Application for a non-material amendment following a grant of planning permission.

ERECTOR OF A TWO STOREY REAR EXTENSION AND
GABLET DORMER WINDOW TO MATCH EXISTING TO FORM
EXTENSIBLE RESIDENTIAL ACCOMMODATION

3/2016/0412

INCREASE THE GROUND FLOOR FOOTPRINT TO THE WEST AND
WITHIN THE INTERNAL GARDEN AREA TO ALLOW A UTILITY AREA

| Drawing no 6007 a/b |

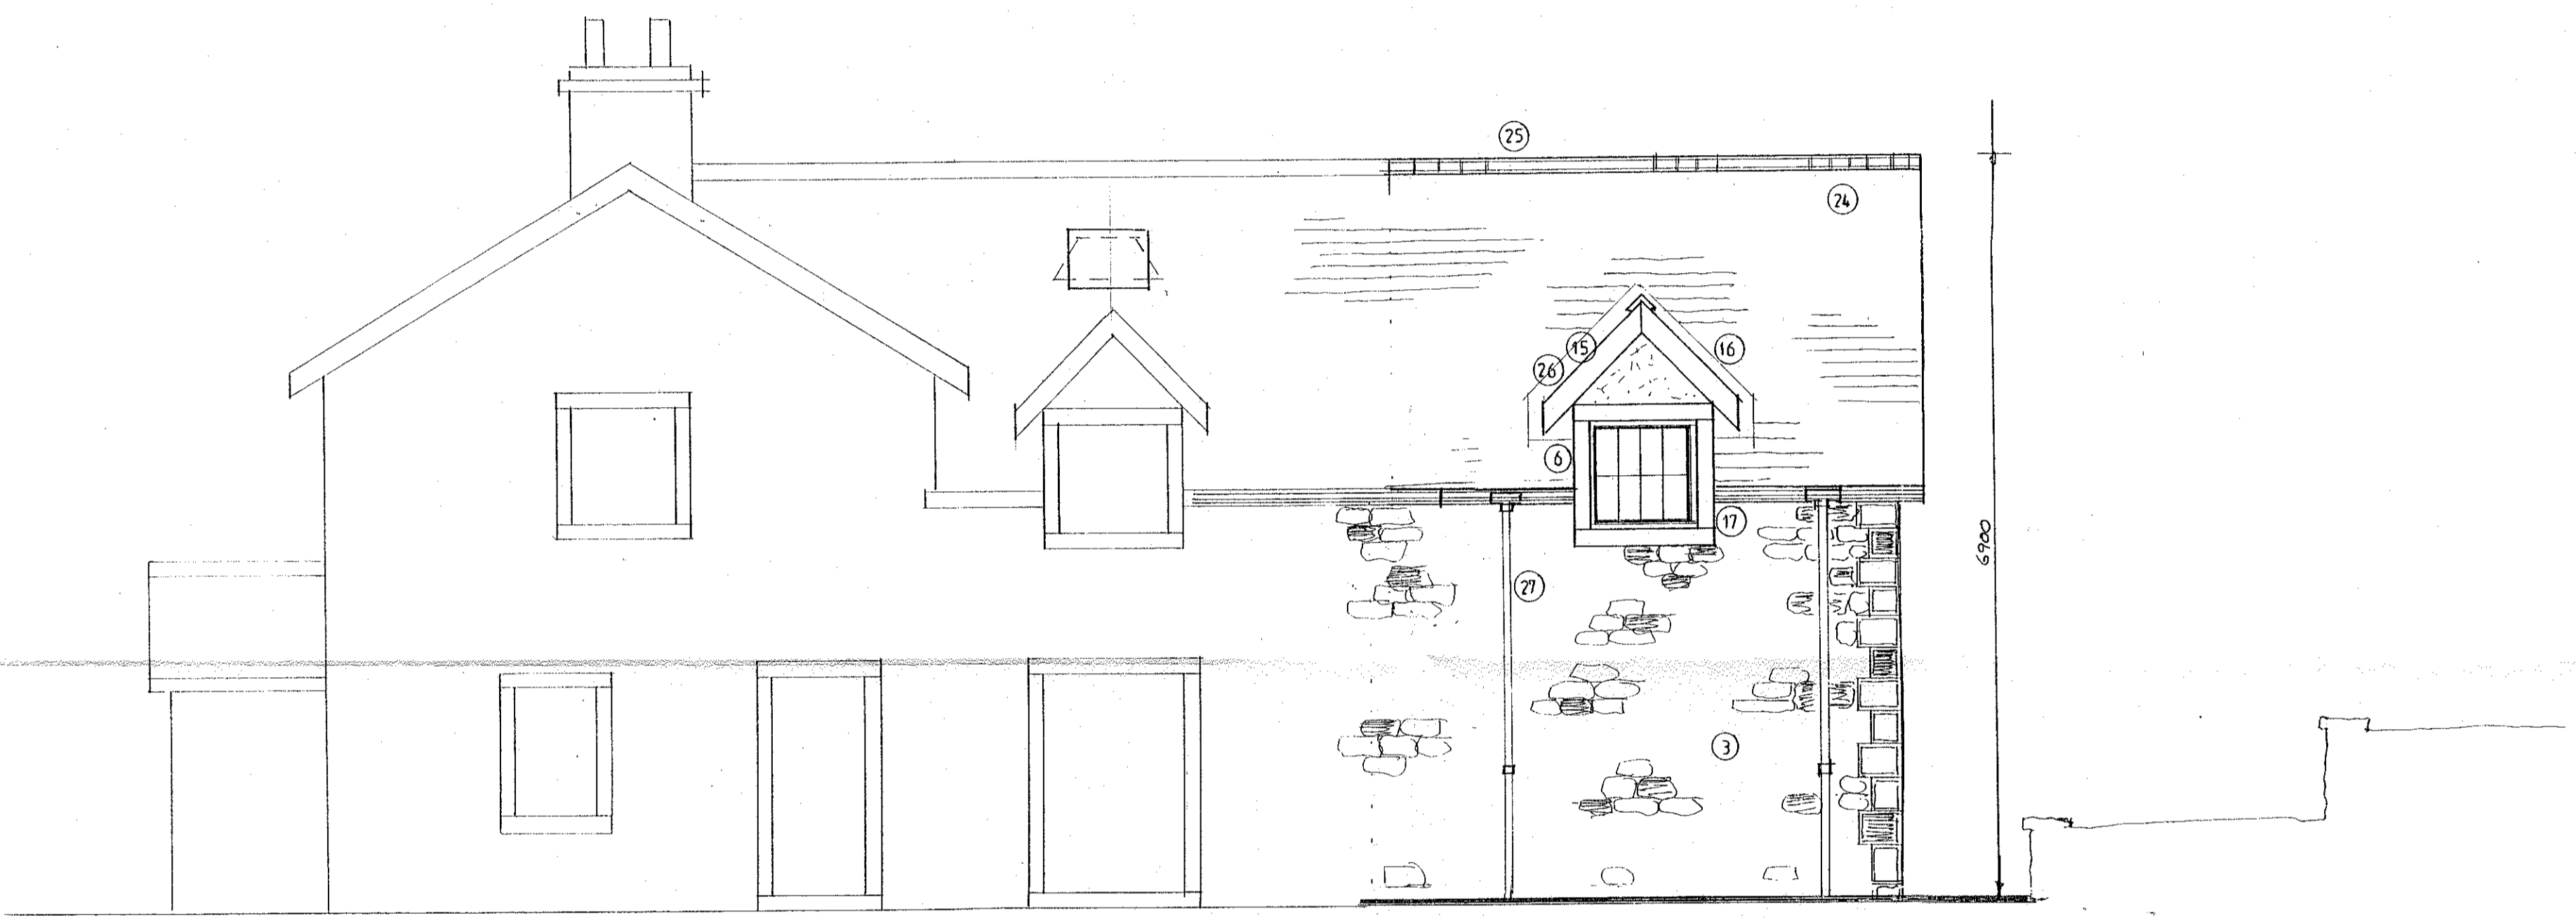
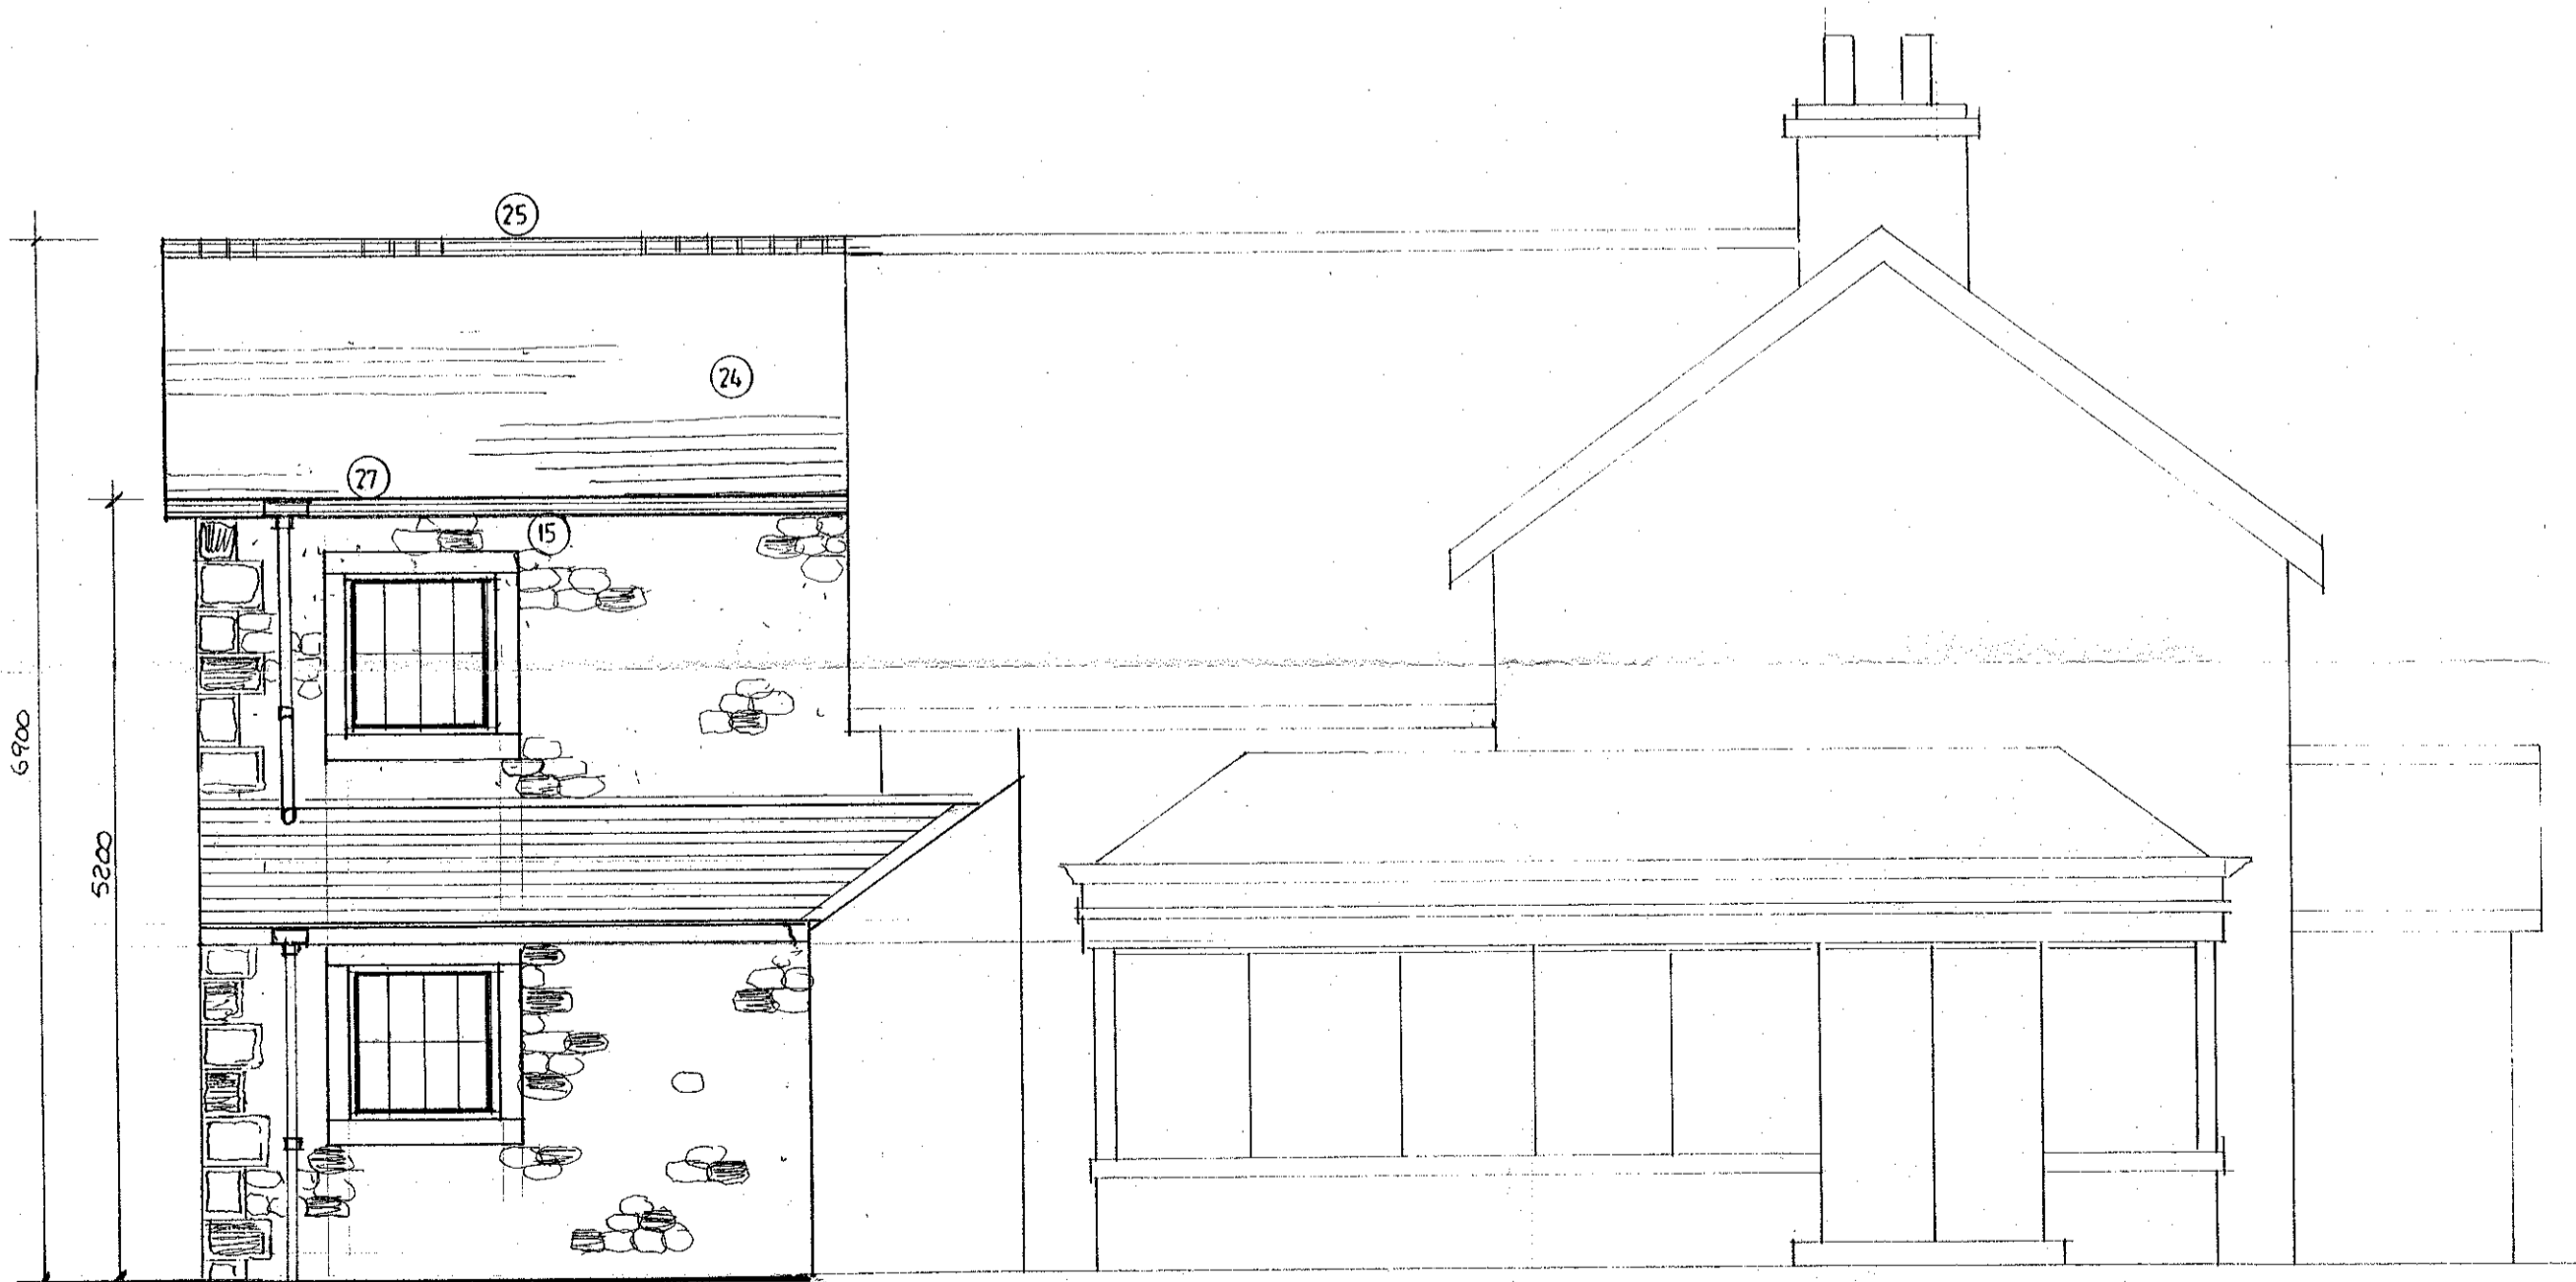
6006a & 6007a

6006/b & 6007/b. AND 6008
